- **The Open Water Channel, which runs across the site is not a suitable discharge point for additional land drainage or exceedance flows.** This is because of the hydraulic and structural inadequacies in the downstream flow routes, as well as serious questions about the legal status of the channel and downstream pipework. There is a very high probability that the currently proposed use of this channel, as a focused water discharge point, will lead to repeated flooding of Far Lower Wood Farm and several properties fronting onto Manchester Road (primarily numbers 42 to 64). The developer and Council planners are aware of this risk and have proposed a crude side-spill overflow arrangement just before the channel enters the garden of Far Lower Wood Farm. However, it is very unlikely that this overflow will be sufficient to prevent flooding. On the contrary, our view is that it will exacerbate flooding in the existing and new properties on both sides of the northern boundary of the site. Our reasons for saying this are covered in the following bullet point concerning the overflow itself. Perhaps the most fundamental mistake the developers and the Council planners have made is to assume

Title.
**General Arrangement of
StormTank MPS
20.4 x 10.225 x 2.2 m**

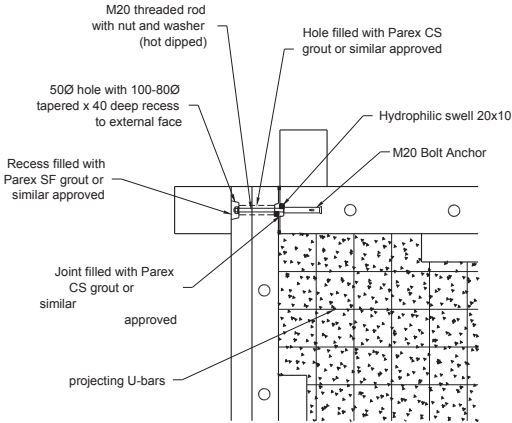
- **Inadequate provision for “exceedance flow” from the storm water storage tank and associated hydro-brake control structure.** As far as we can see, the proposals do not incorporate ANY provisions for dealing with “exceedance flows” from the storm water storage tank or its associated Hydro-Brake control arrangement. There is certainly no identifiable exceedance flow route down to Manchester Road. It is possible that some exceedance flow would flow from West to East back along the highway surface before discharge to the open water channel running through the site. We have shown in previous points that this is an unsatisfactory and unsafe point of discharge. However, we think it more likely that exceedance flows from the storm water storage tank will flow in an uncontrolled manner through the gardens (and perhaps the interior) of house plot number one. Alternatively, the exceedance flows may escape through the manhole covers on the water storage tank and flow in an uncontrolled manner down the steep hillside towards Manchester Road. It is likely that this will cause erosion of the steep

- **Inappropriate siting of the storm water storage tank.** We have pointed out, many times over, that the storm water storage tank will require flat vehicular access for maintenance purposes. We cannot understand why the developer and the Council drainage technicians have ignored this basic and fundamental requirement, by siting the storage tank on a steeply sloping Pennine hillside and maintaining the steep slope above the tank roof.. Further arguments regarding this problem will be provided on request. NB: If there are any residual problems with the storm water storage tank it is likely that this will lead to adoption problems and in turn to the ongoing responsibility falling on the proposed site management company. The potential costs and legal responsibilities of this are not insignificant and may cause problems with mortgages and house ownership. It is therefore essential that the potential problems with the storm water storage tank are resolved BEFORE the planning conditions are discharged.

- Re-siting / redesigning the storm water storage tank, to provide hard level access for motor vehicles.
- Creating an identifiable and secure exceedance flow route down to Manchester Road from the storm water storage tank and its associated control structure.

Drawn	Chkd	Date	Scale	Dwg. No.
HN		AUG 24	as shown A2	E19/7567/207B

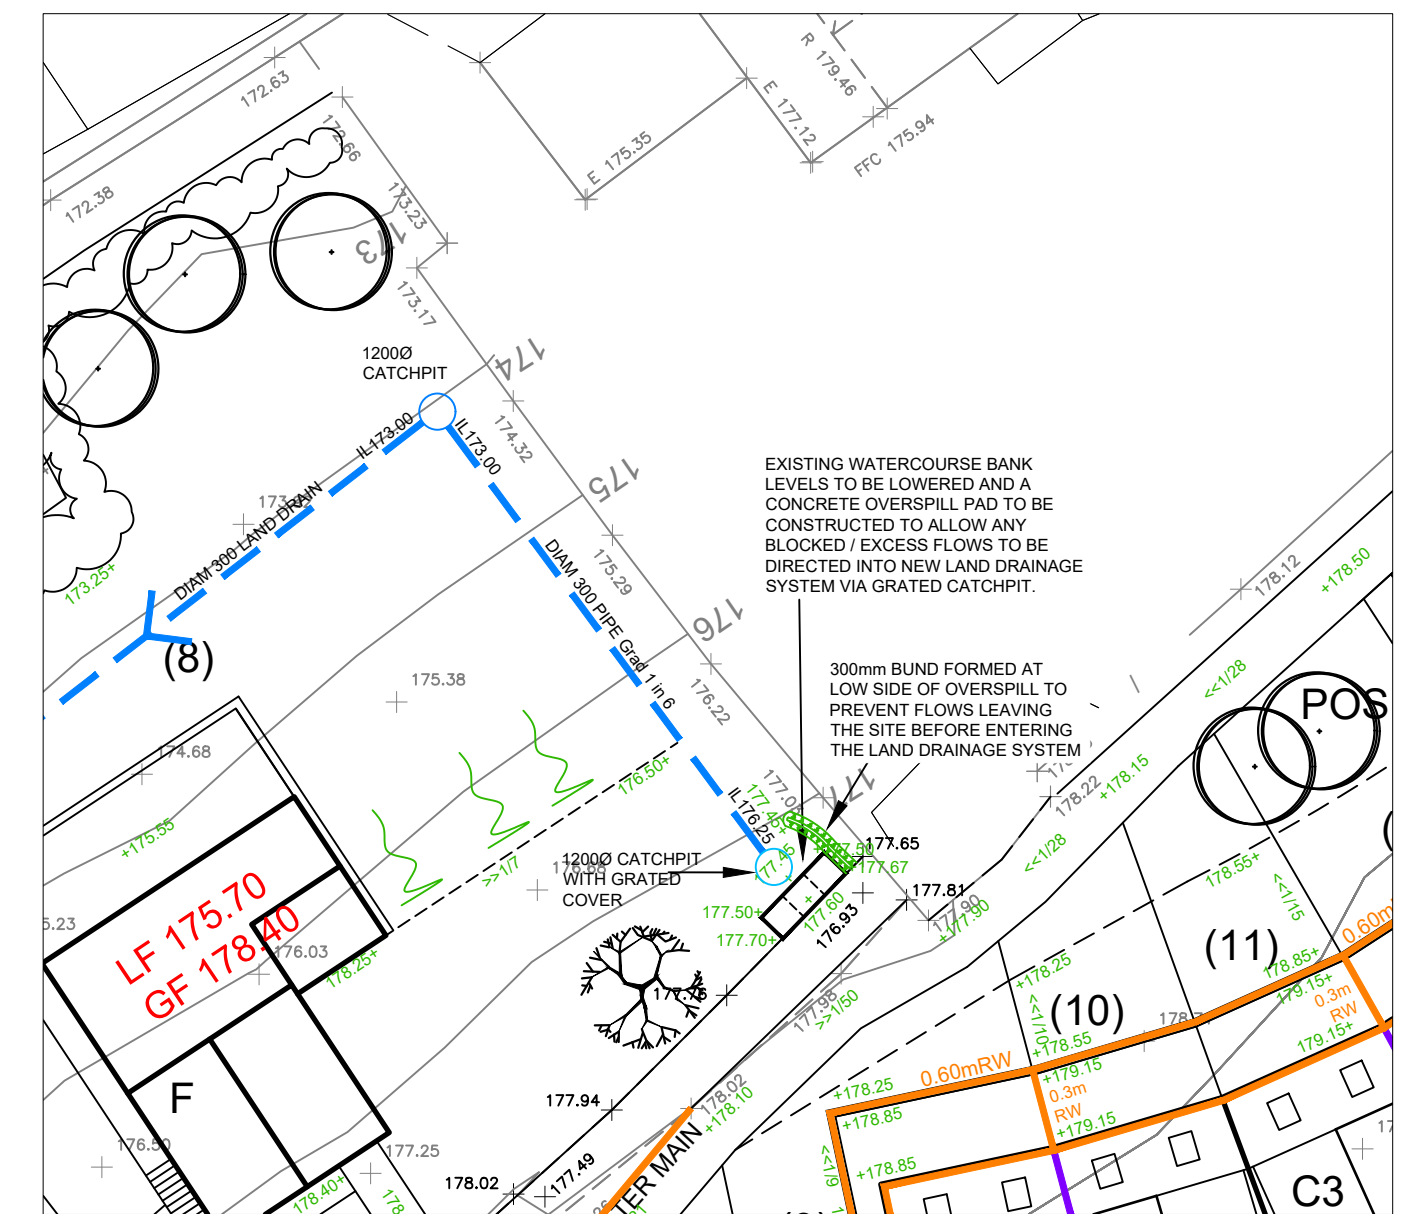
- **The concrete side-spill overflow on the open water channel is very crude and will do little to mitigate the frequency and severity of flooding of downstream properties.** To be effective, side-spill overflows need to be situated on well maintained, steady flow / laminar flow channels. They are not appropriate for turbulent, variable flow conditions on poorly designed and maintained water channels subject to siltation. The channels need to have a properly designed control device, such as a penstock, on the main throughflow channel. In most cases they will also incorporate full cross section, concrete linings upstream and downstream of the overflow itself. (to inhibit siltation and ensure laminar flow). In the current inadequate proposals, the side-spill concrete overflow weir would be situated on a lowered earth banking (which may be subject to erosion), on a water channel which has highly variable flow characteristics. This is because of the propensity to siltation / erosion and its use as a land drainage and exceedance flow channel. We are also deeply sceptical about future maintenance of the earth channel and overflow structure, by the proposed “site management

company”, especially in such a safety and flood critical position. In our view the proposed overflow will do little to prevent flooding of downstream properties and is little more than non-professional “window dressing”. As such it is not acceptable.

- **Inappropriate configuration of the open water channel and integration with the land drainage system.** As noted in the previous point, an estimated 80% plus of flow from the land drainage system will discharge into the open water channel which is an unsatisfactory and unacceptable point of discharge, because of downstream hydraulic and structural inadequacies. However, the open water channel is only approximately 50 metres long and its configuration is also rather bizarre. There are two 450mm diameter pipes feeding into the channel at the Western end and one 225mm and one 150mm diameter pipe at the other end. The 225mm pipe and 150mm pipe combine, before

feeding into the open channel directly opposite the proposed concrete overflow weir, thus completely negating any hydraulic viability the overflow might have had. It also seems utterly bizarre to discharge any of the four land drainage connections into the open channel so close to the proposed overflow weir, which effectively means that flow is being removed from the channel almost as soon as it has been added. This is crazy. and the overflow has a virtual zero chance of working properly with this inflow / outflow configuration. Quite simply the drainage designers are not thinking how this system will operate in storm conditions. This leads to a totally ridiculous, ineffective design of the channel and the side-spill overflow.

- AVOID USING THE OPEN WATER CHANNEL AS THE PRIMARY LAND DRAINAGE AND EXCEEDANCE FLOW DISPOSAL POINT
- Reverting the open water channel mainly to its original “water supply” function

- Removing excess / additional land drainage from the open water channel
- Redesigning the land drainage system in the North-West quadrant of the site, to take most of the land drainage flow from the whole site directly down to Manchester Road
